Comment Correction Required / Response Report

Application No. PDZL-24-0005

BANNING LEWIS RANCH - VILLAGE C
LAND USE PLAN
COLORADO SPRINGS, CO
COVER SHEET

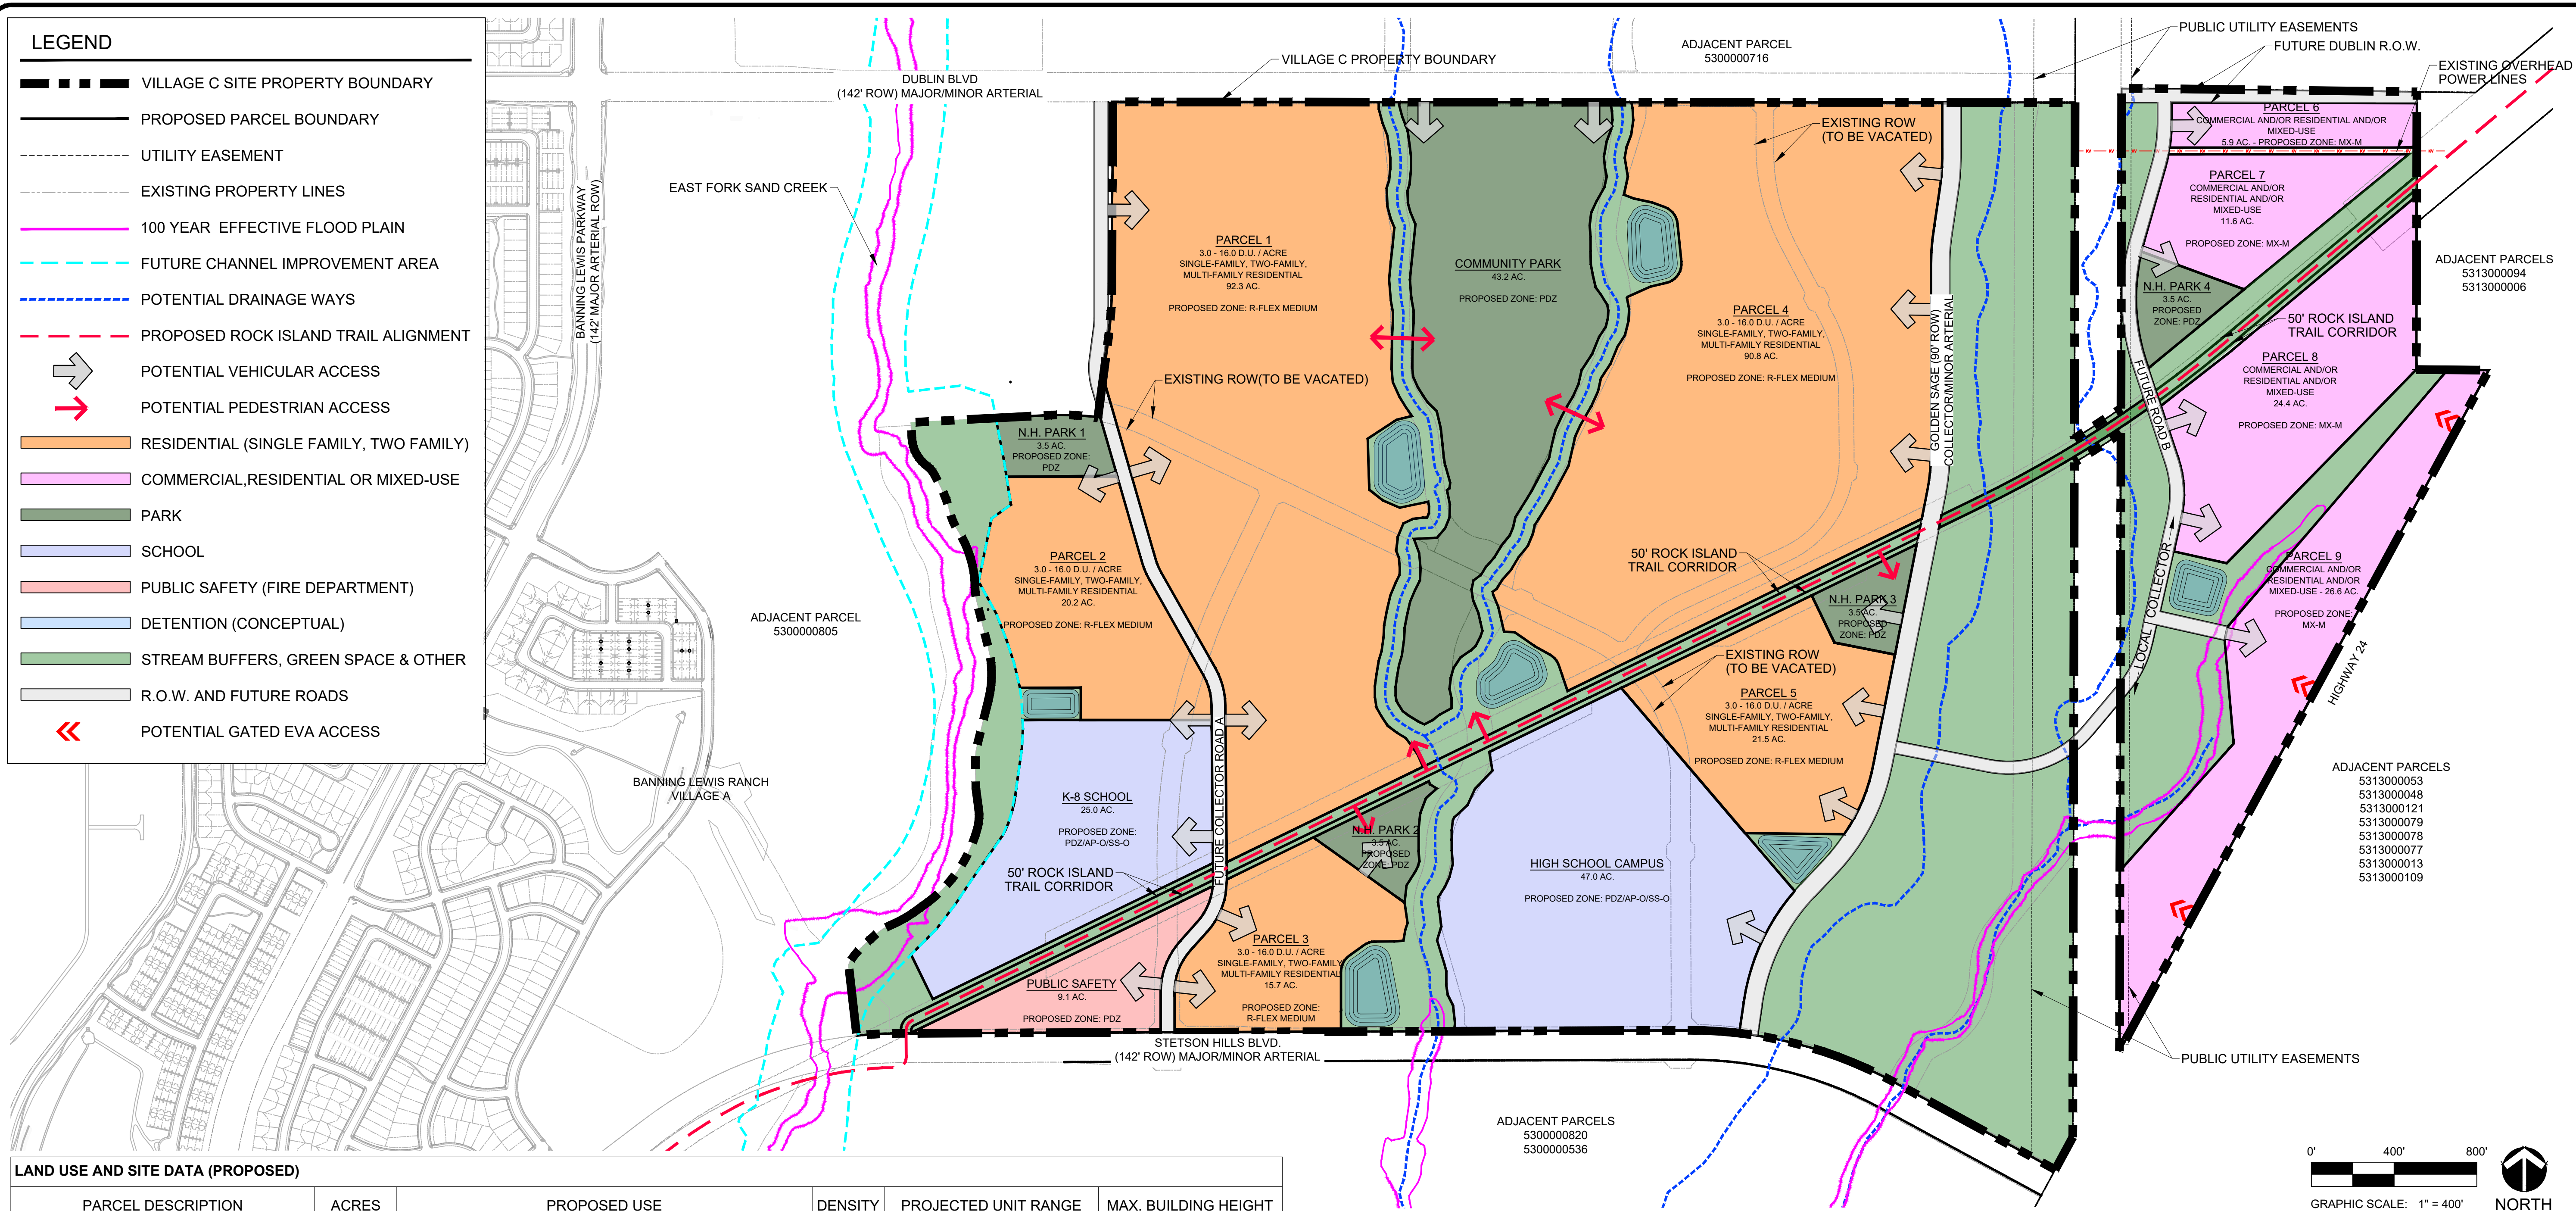
18	1	Free Text	Jonathan Scherer : City Engineering - SWENT	Open	Add a note calling out channel improvement requirements associated with this Site. Include responsible party, long-term maintenance responsibility (private/public), and timing requirements.	RESPONSE
19	2	Callout	Jonathan Scherer : City Engineering - SWENT	Open	Will water quality treatment also be provided?	RESPONSE Yes conceptual ponds will be for water quality purposes. Location of ponds will be

27	2	Note	Joel Dagnillo : City Engineering Dev Review	Open	Call out roadway classification of Future Road A and B.	RESPONSE: Updated
55	1	Note	Tamara Baxter : Planning	Open	Refer to CDOT comments dated 11/1/24, CDOT Traffic Review comments, and US 24 Garrett Woodman Traffic Report provided by CDOT. All have been uploaded seperately.	RESPONSE: Please see included T.I.S comment response letters from S.M. Rocha dated March 26, 2025.
58	1	Note	Tamara Baxter : Planning	Open	Please refer to comments provided on this document with city file PDZZ-24-0003.	RESPONSE: Noted.
5	1	Note	Allison Stocker : Planning	Open	Note 15 is redundant as this information is already noted in Note 3	RESPONSE: Updated.
13	1	Note	Allison Stocker : Planning	Open	What community benefits are being provided as a part of the PDZ zoning? See Section 7.2.7 for options. Community amenities could be possibly satisfied by providing a high-quality network of trails throughout the development and along the streams (in addition to Rock Island), but you will need to clear all options with the case planner.	RESPONSE: Zoning has been revised to R-flex Medium and MX-M per recommendation of planning staff.

65	1	Callout	Tamara Baxter : Planning	Open	Which plans and reports?	RESPONSE Note removed, no longer relevant.
66	1	Callout	Tamara Baxter : Planning	Open	Is GN #20 at the time of development plan?	RESPONSE Note updated.
67	1	Note	Tamara Baxter : Planning	Open	Since Master Plans and Concept plans are not Land Use Plans, for BLR MP, please include a sheet that reflects the BLR Master Plan, clouding the area of change. Also, include legend that reflects land use areas. Refer to City file CPC MP 87-00381-A22MJ18	RESPONSE: Sheet has been added please see sheet number 5 of 10.
12	2	Callout	Allison Stocker : Planning	Open	Please label Creek	RESPONSE Labeled.

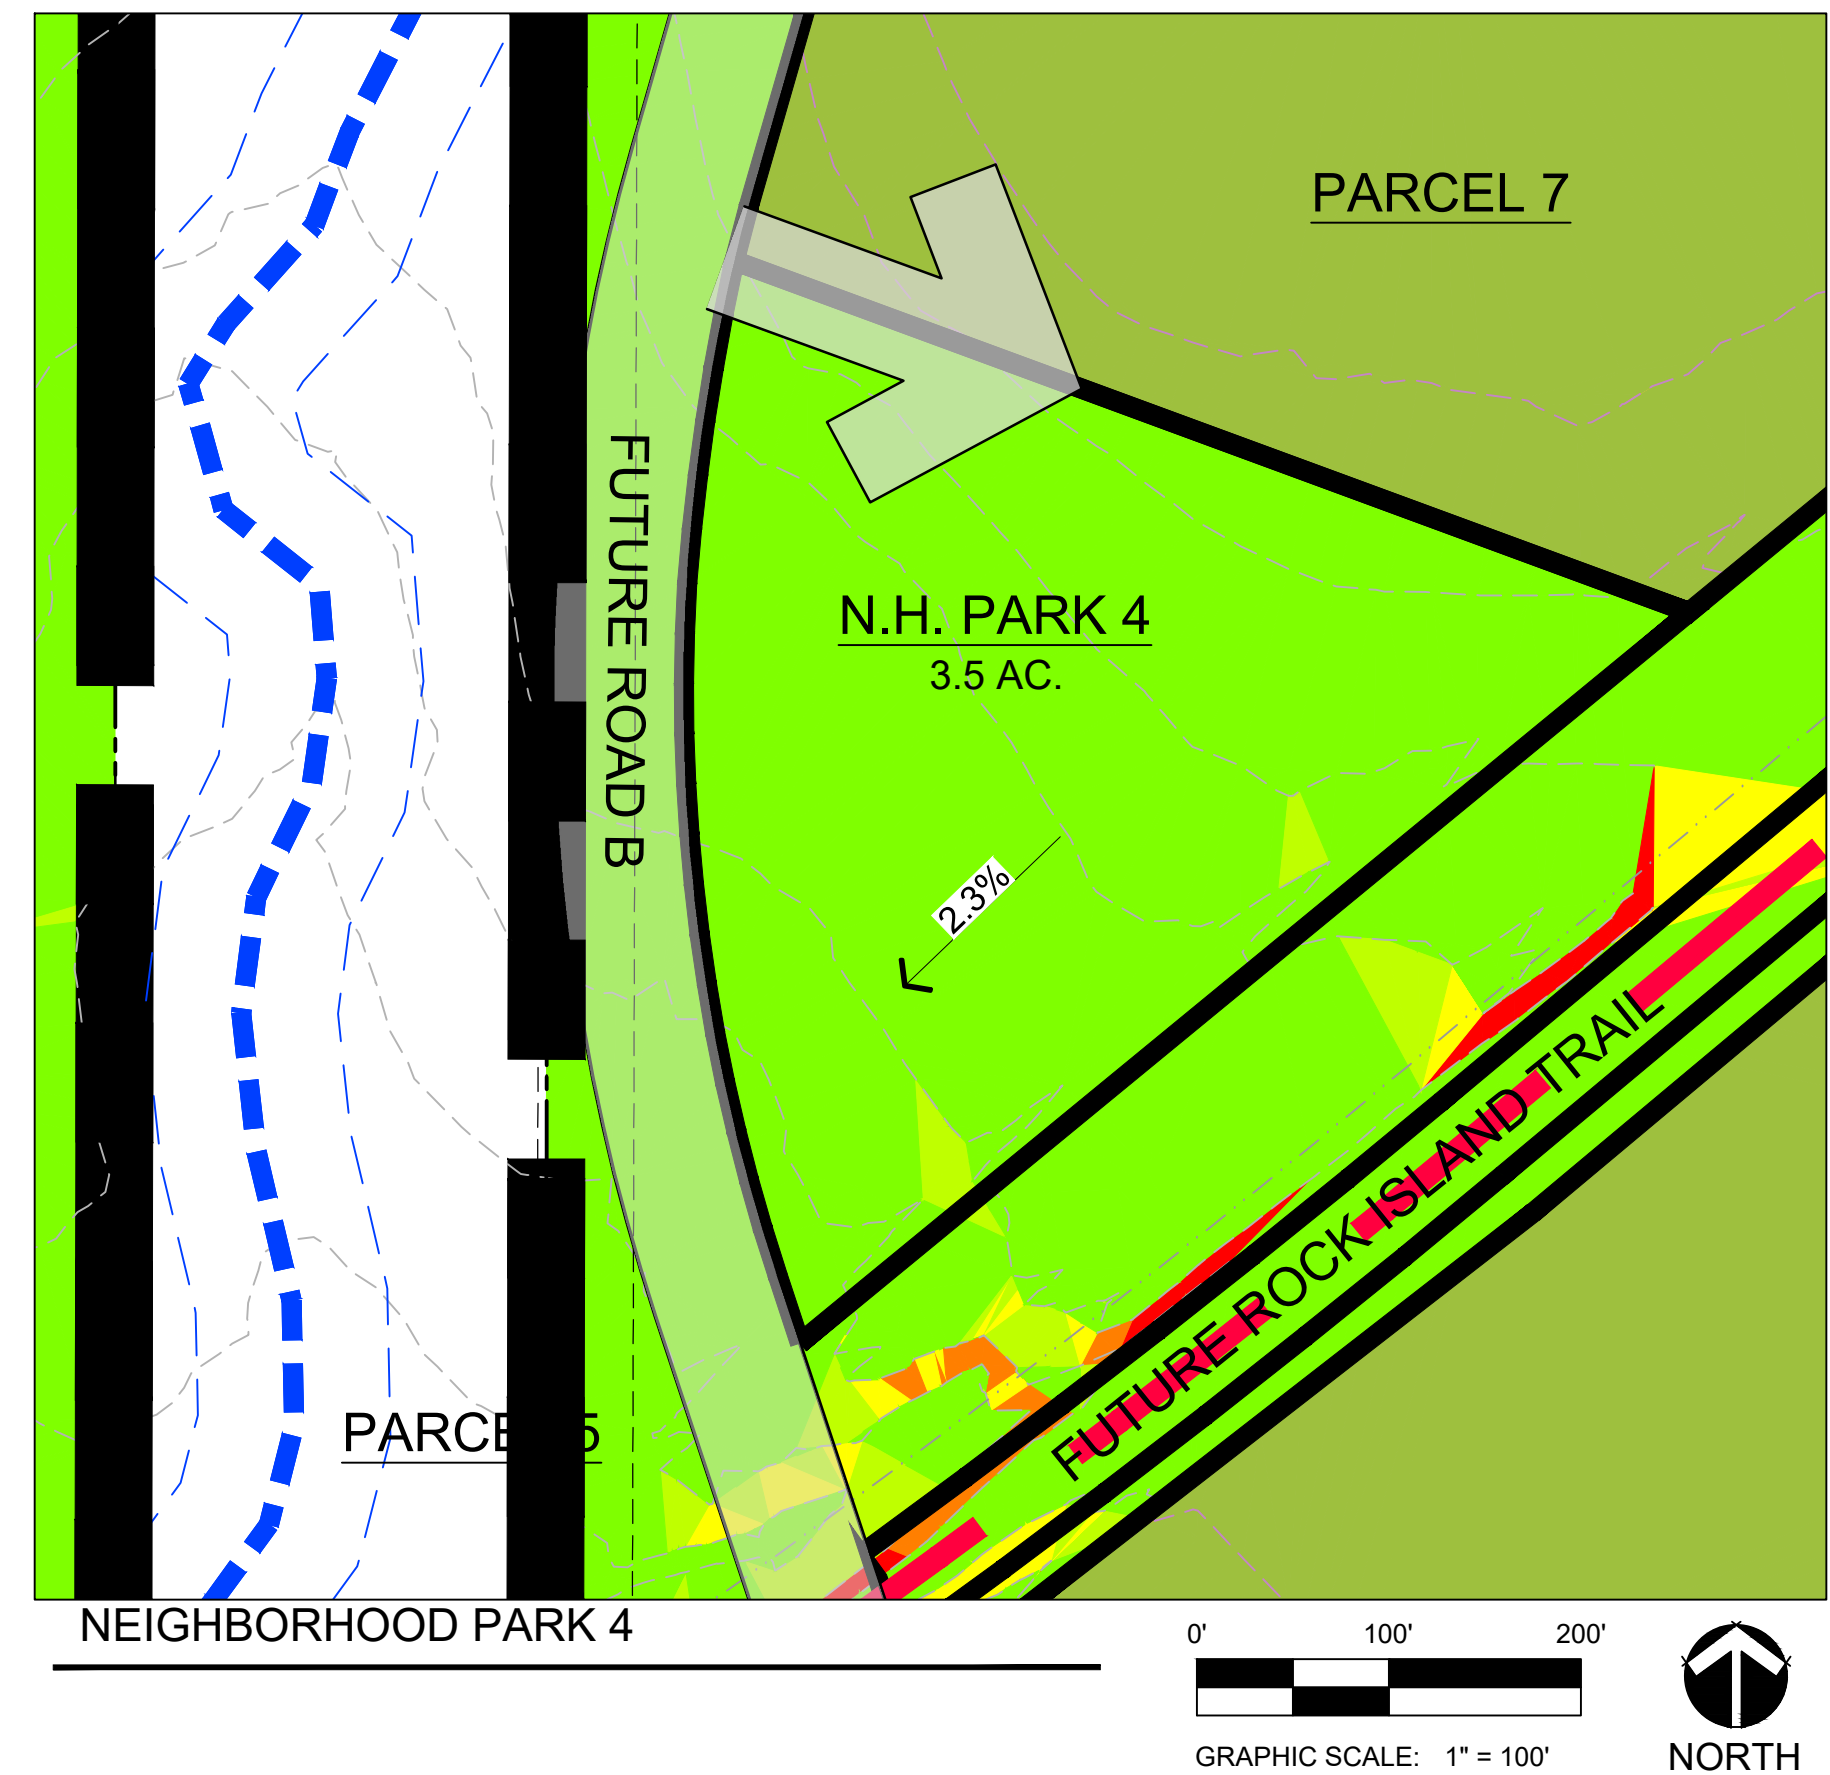
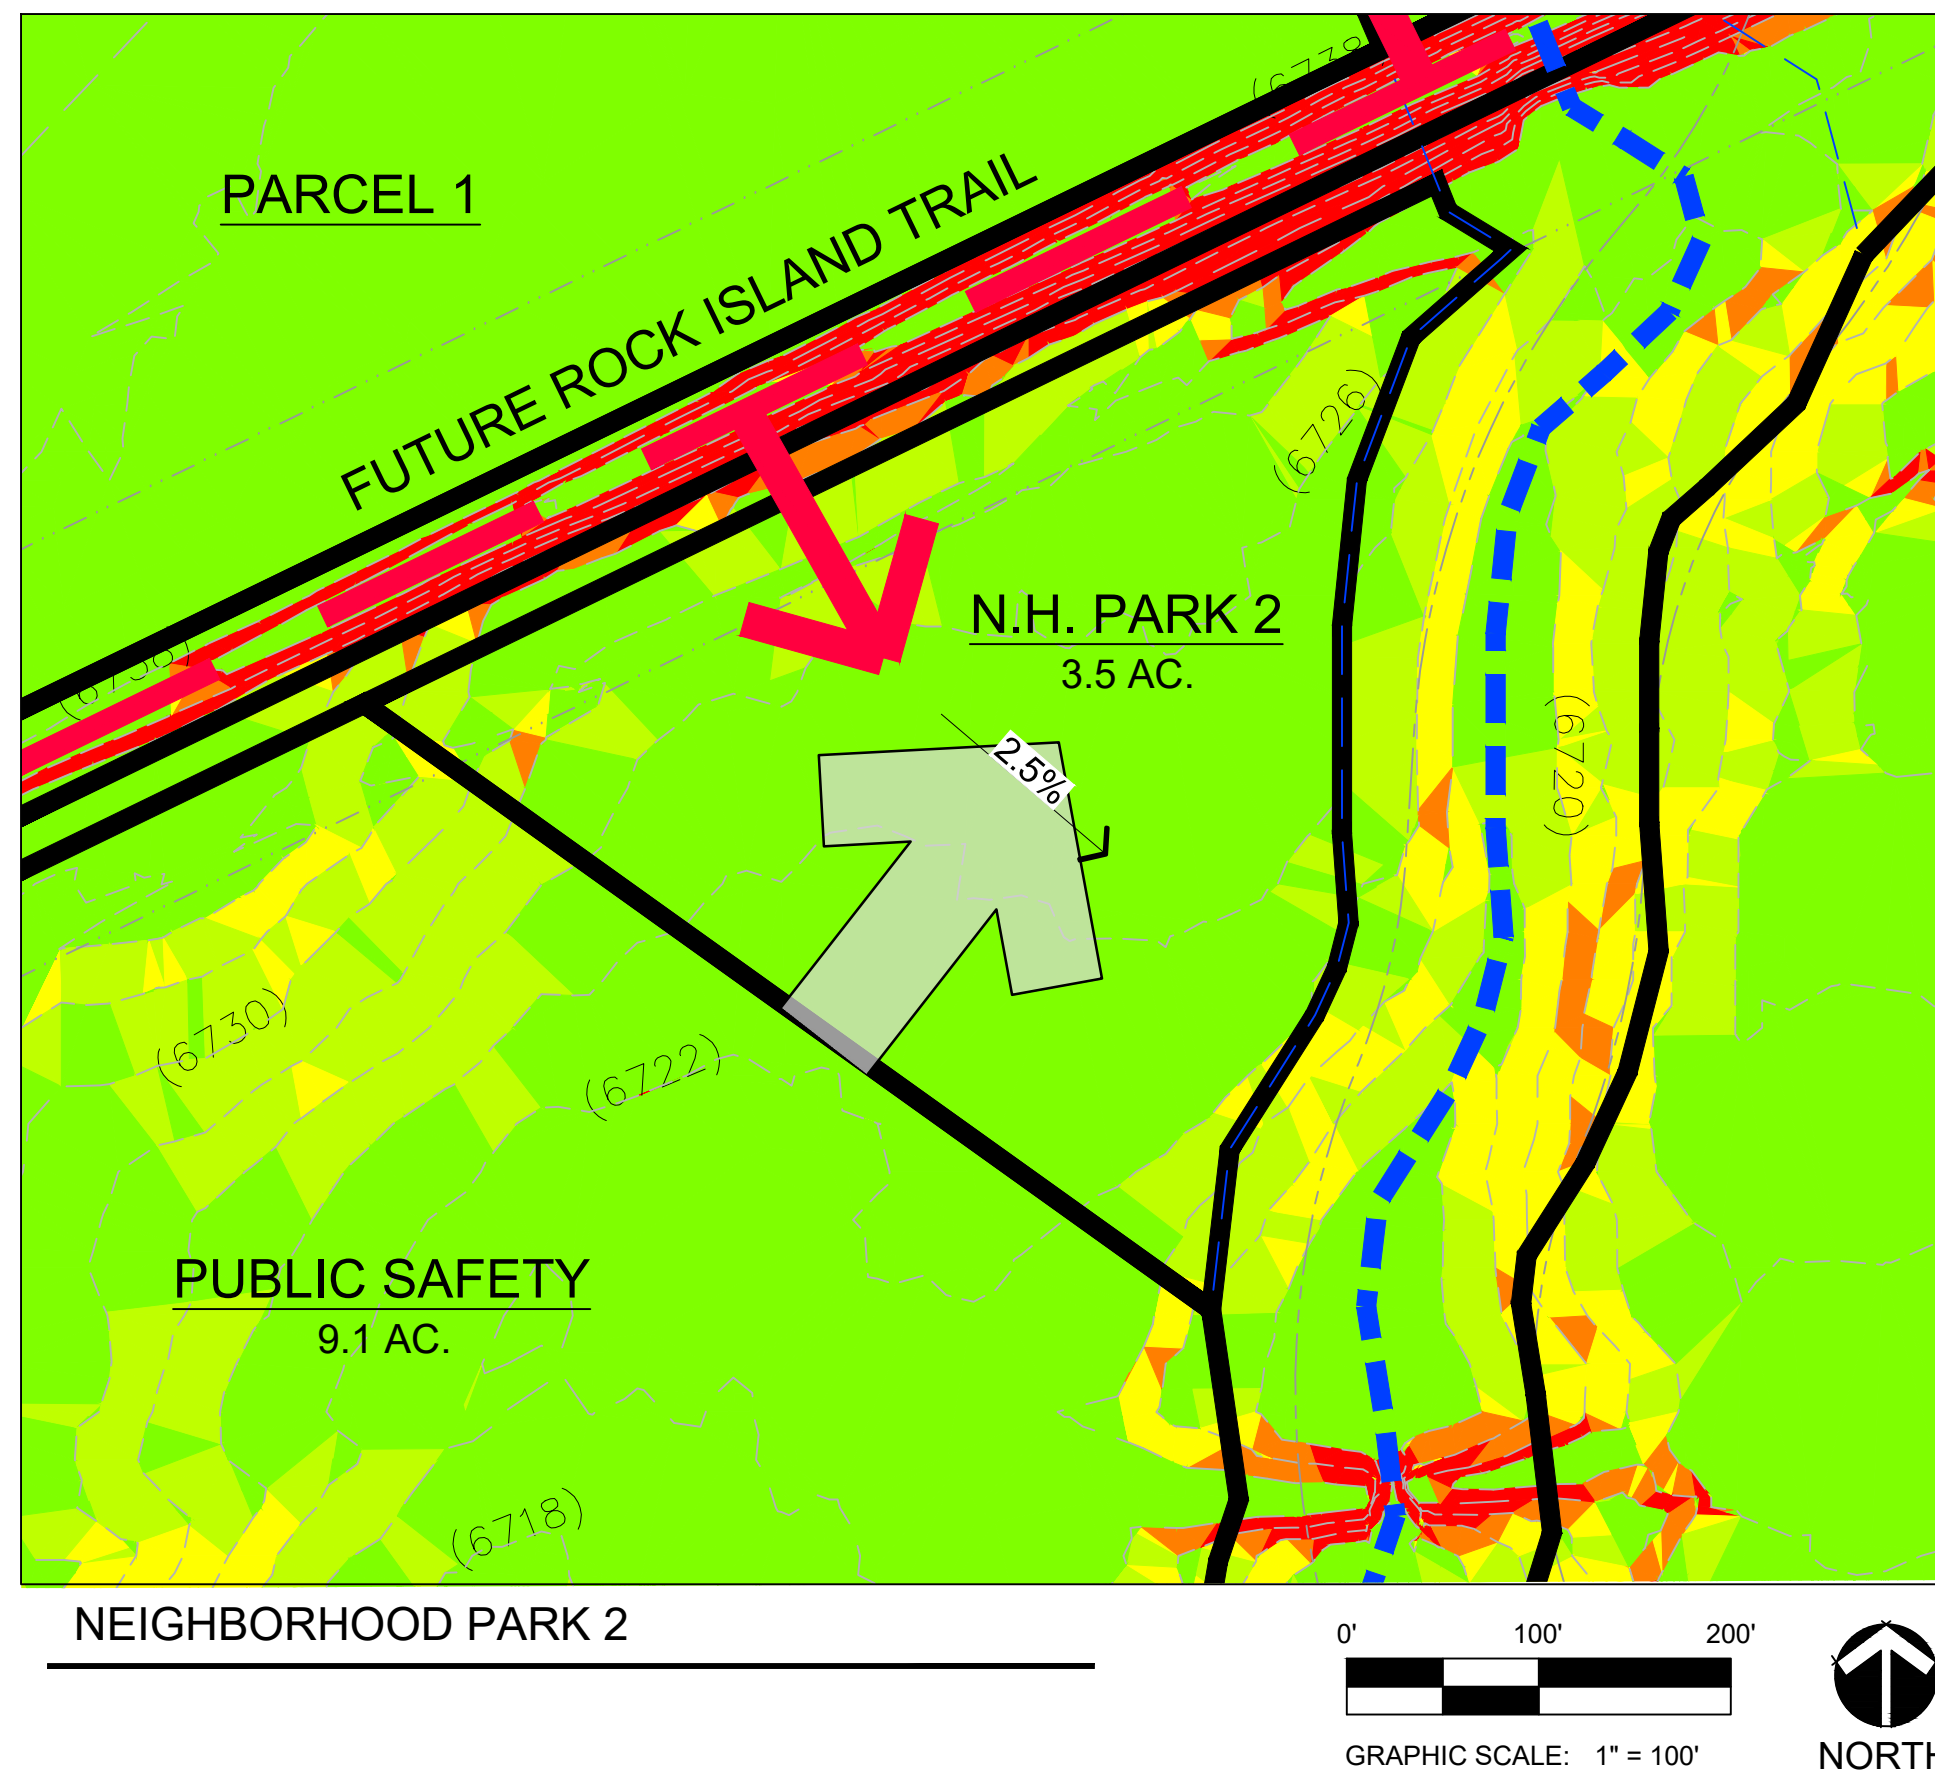
2	2	Note	Zaker Alazzeh : City Eng - Traffic Engineering	Open	1- The developer shall dedicate appropriate ROW along northern property line of Parcel 6 side at Dublin Blvd. This dedication must be consistent with the western property line ROW. 2- Please update the traffic study. Details are shown in the traffic impact study review comments.	RESPONSE: Please see included T.I.S comment response letters from S.M. Rocha dated March 26, 2025.
15	1	Free Text	Jonathan Scherer : City Engineering - SWENT	Open	Show and label all major drainageways on the vicinity map.	RESPONSE: Added.
16	1	Free Text	Jonathan Scherer : City Engineering - SWENT	Open	In the Floodplain Statement, include which flood zone the Site lies within (e.g. Zone X).	RESPONSE Added.
17	1	Free Text	Jonathan Scherer : City Engineering - SWENT	Open	The Site also appears to be located within Panel 08041C0561G. Please include within the Floodplain Statement.	RESPONSE Added.

45	2	Note	Caroline Miller : Planning	Open	Have there been considerations of moving the N.H. Park 3 east of the utility easements to serve the residential communities of Parcels 6, 7, and 8? It is still within a half mile of walking distance along the Rock Island trail which is park standard, but by vehicle park access is further. Phasing may also play a role in this.	RESPONSE We agree that there should be a park east of the utility easement. We have added a 4 th park to serve this area. We are projecting (4) 3.5 acre Neighborhood parks which exceeds the requirement projection of 12.151 acres.
46	2	Note	Caroline Miller : Planning	Open	As shown, there is a need for pedestrian bridges to allow connection to the Community Park site. Will the developer provide those?	RESPONSE Yes the developer will provide access over the drainageways to the community park. The type of crossing has not been determined.

54	2	Note	Caroline Miller : Planning	Open	Please add a note that the Rock Island Trail Corridor easements will be provided to the City at time of adjacent development.	RESPONSE: Rock island trail has an existing easement that varies in width 100-200'.
68	2	Callout	Tamara Baxter : Planning	Open	Please expand if 'dwelling - two family (duplex)' will also be allowed per UDC.	RESPONSE *Note has been added for clarification.
75	2	Callout	Tamara Baxter : Planning	Open	Refer to Staff comments on proposed PDZ zoning, not meeting eligibility for PDZ district. Conventional zoning is encourage. Thus, density for specific parcels make need to be updated.	RESPONSE: Zoning has been revised to R-flex Medium and MX-M per recommendation of planning staff.
